**BRAMFORD TO TWINSTEAD DCO APPLICATION
RELEVANT REPRESENTATIONS**

Thank you for the notifications that the Planning Inspectorate has accepted the above application and that interested parties have until 18 July 2023 to submit Relevant Representations. Please therefore accept this letter as a response from Suffolk County Council (the Council) to the Planning Inspectorate's request.

DEDHAM VALE EAST SEALING END COMPOUND:
 PLAN VIEW
 SCALE 1:200

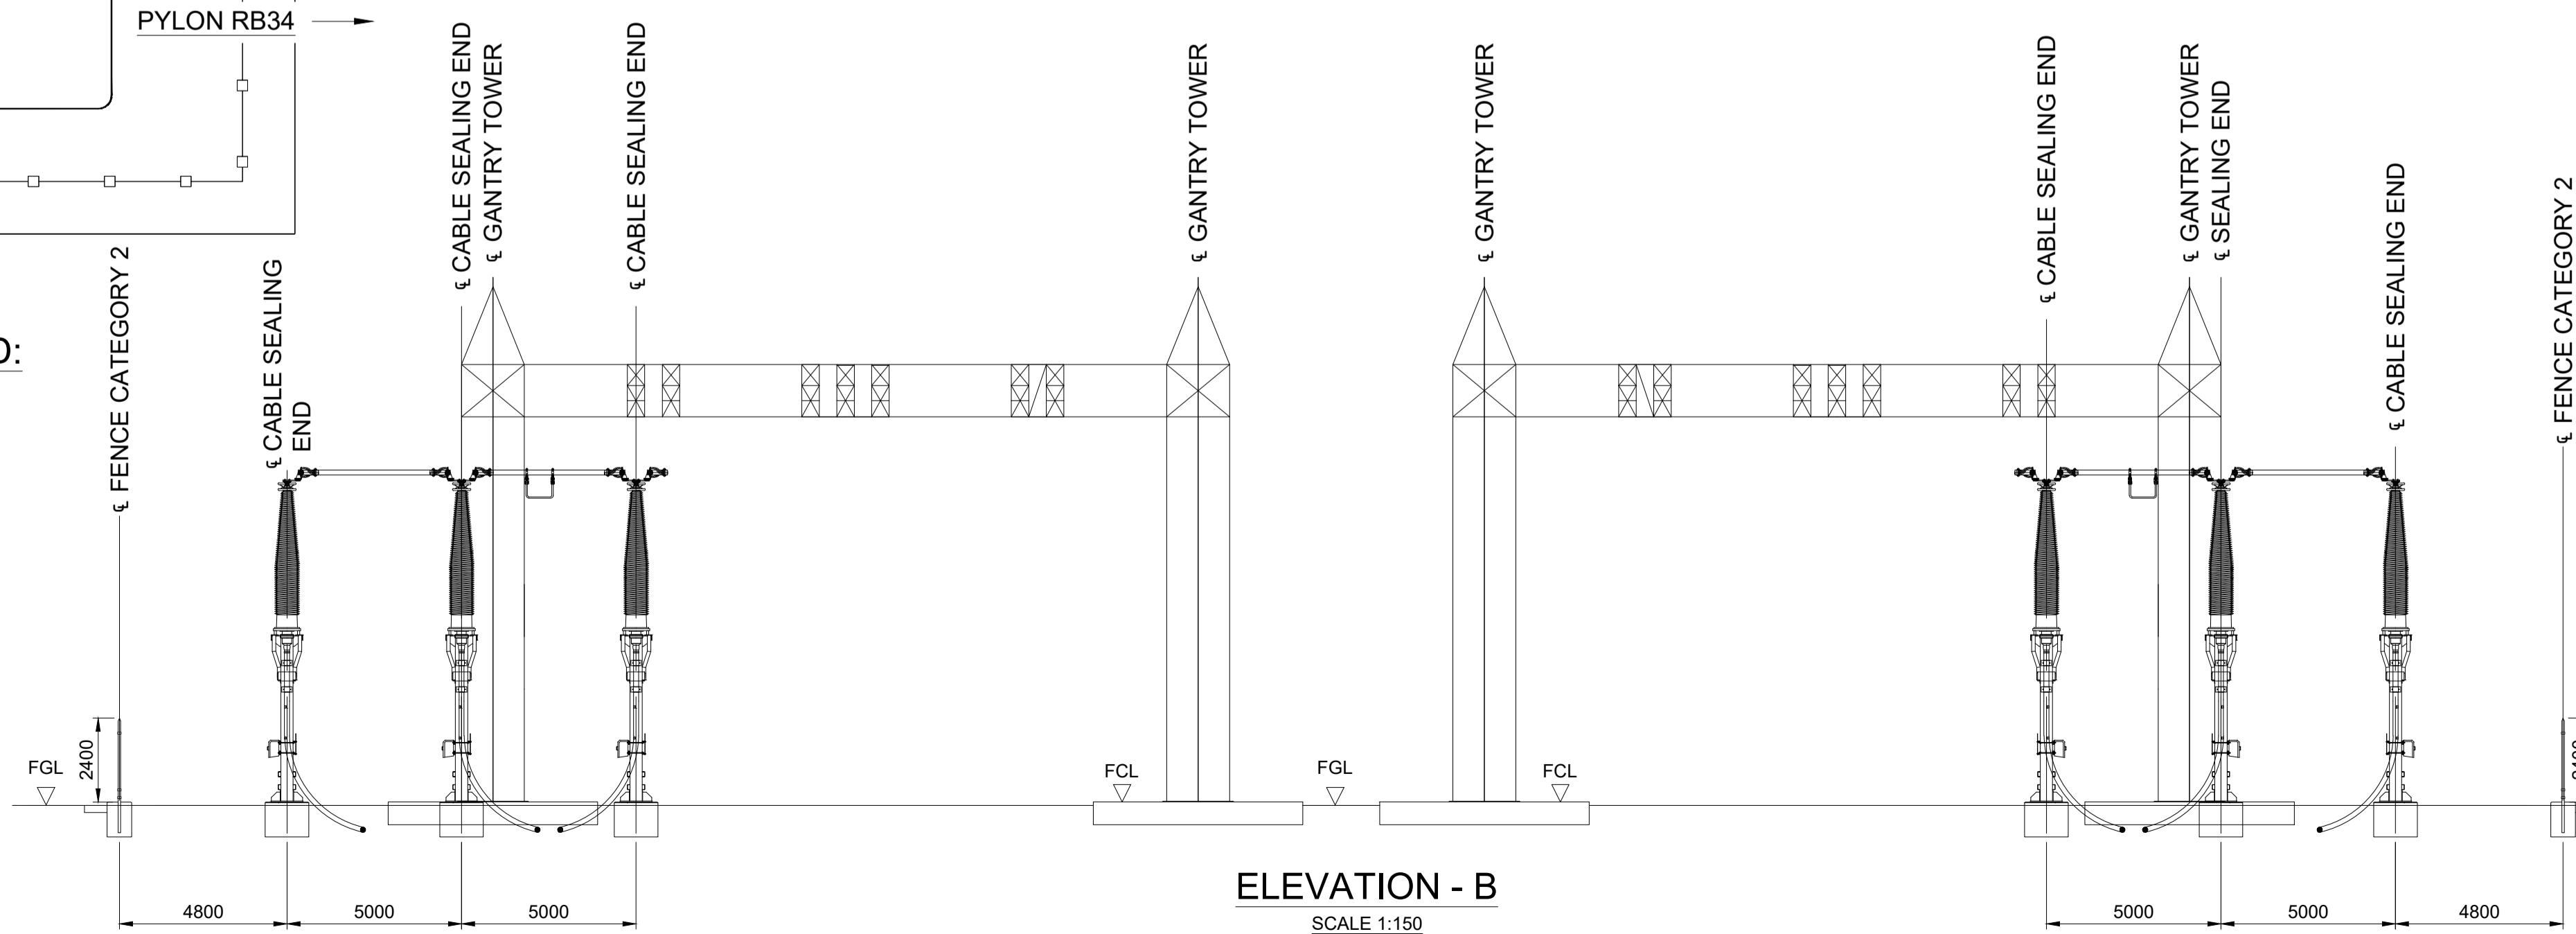
- d) Cable Sealing End Compounds; the Council welcomes the work done to reduce the potential landscape impacts although further detailed mitigation proposals will be required for example in respect of the establishment and management of planting designed for landscape mitigation.
- e) Climate Change; in accordance with the County Council's Energy and Climate Adaptive Infrastructure Policy (2023), the landscaping and planting across the project should be designed, planted and maintained in such a way that it is responsive to local conditions and adaptable to the impacts of climate change.
